Our ref: OWF/Thanet Ext.
PINs ref: EN010084
Registration
ID No.: 20012618

Please find below the post-hearing submissions from Historic England, as requested for Examination Deadline 3.

Written submission – Actions arising from the Issue Specific Hearing 4 (ISH4) held at Discovery Park, Sandwich on 19 February 2019 (Historic Environment)

Figure: 12.51b
Viewpoint 25: Trinity Beacon, Goodwin Sands

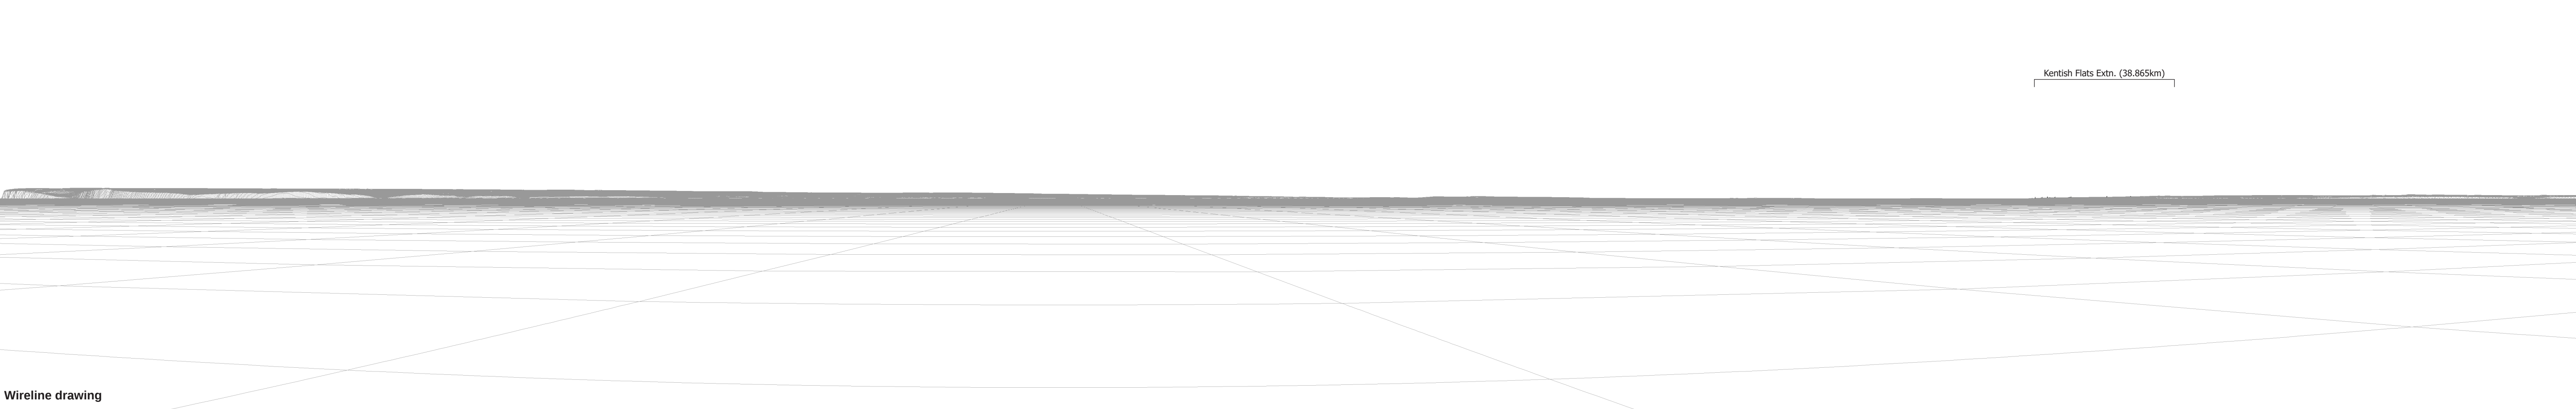
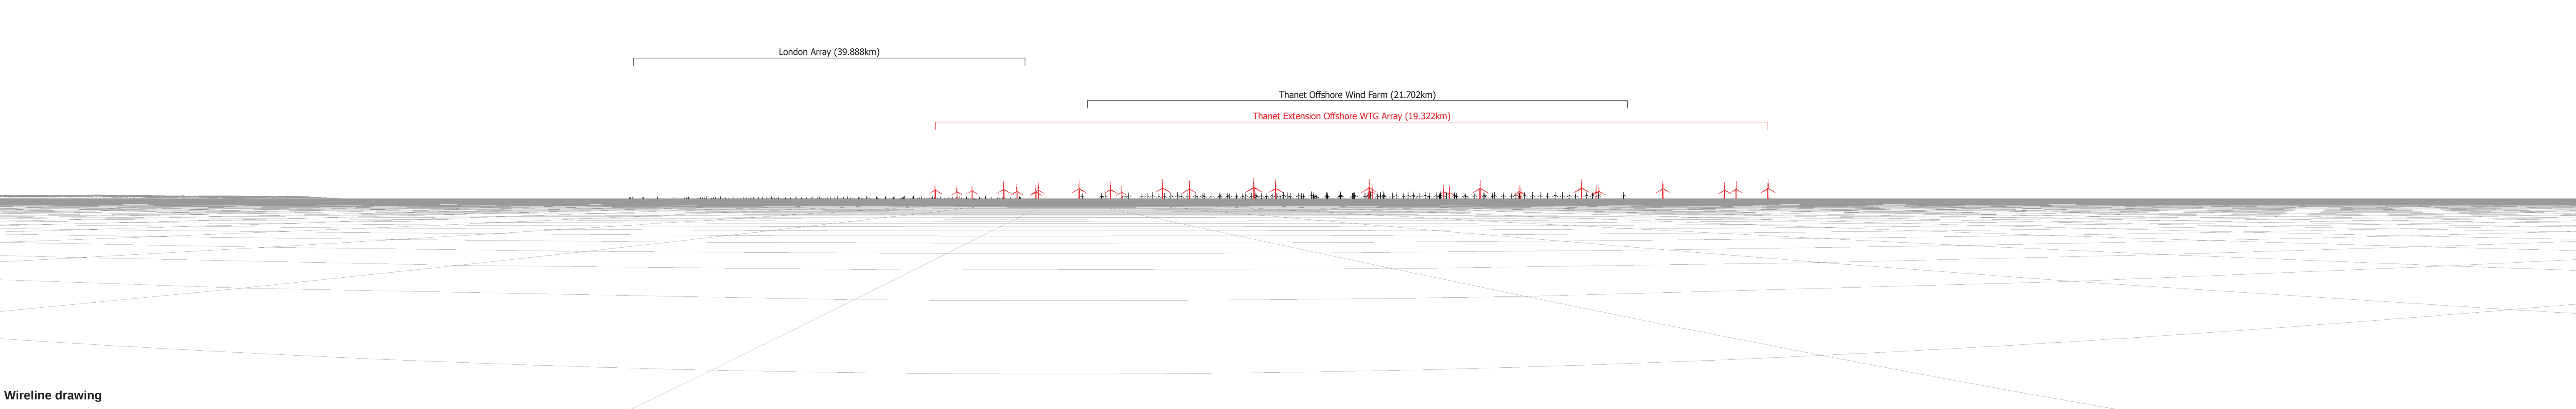
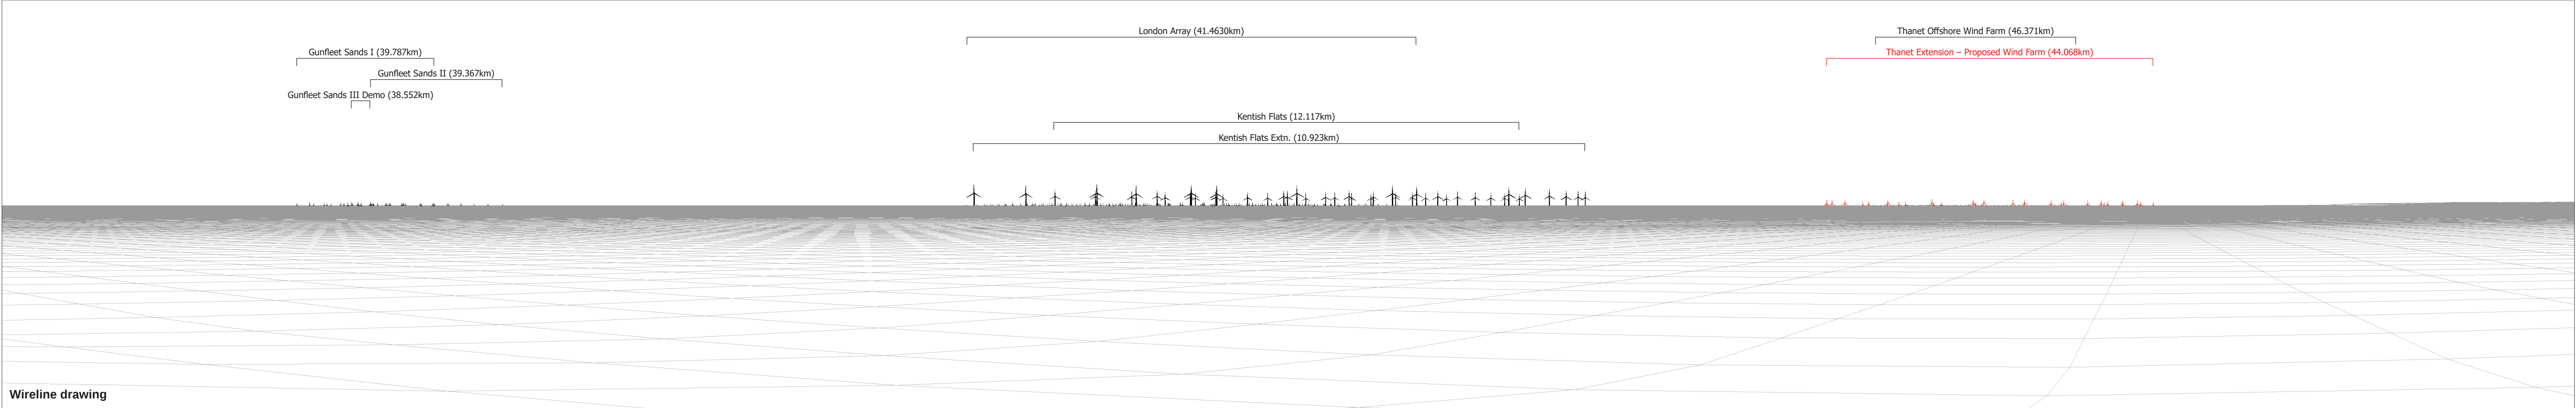
Historic England has reviewed figures 12.51b and 12.51c (*Vattenfall Wind Power Ltd, Thanet Extension Offshore Wind Farm Environmental Statement, Volume 6, Annex 12-2-2: SL VIA Photomontage*) in order to answer question 1 about the White Cliffs of Dover. We think this question relates to the white cliffs as they are understood as a component of the South Foreland Heritage Coast (as defined by agreement by

Natural England and the relevant Local Authority) rather than for the way in which they form the setting of designated heritage such as Dover Castle. Although being defined as a Heritage Coast would suggest this issue is specific to the historic environment, we think Natural England are nonetheless best placed to advise on this question. We are able to provide further clarity on our answer if helpful.
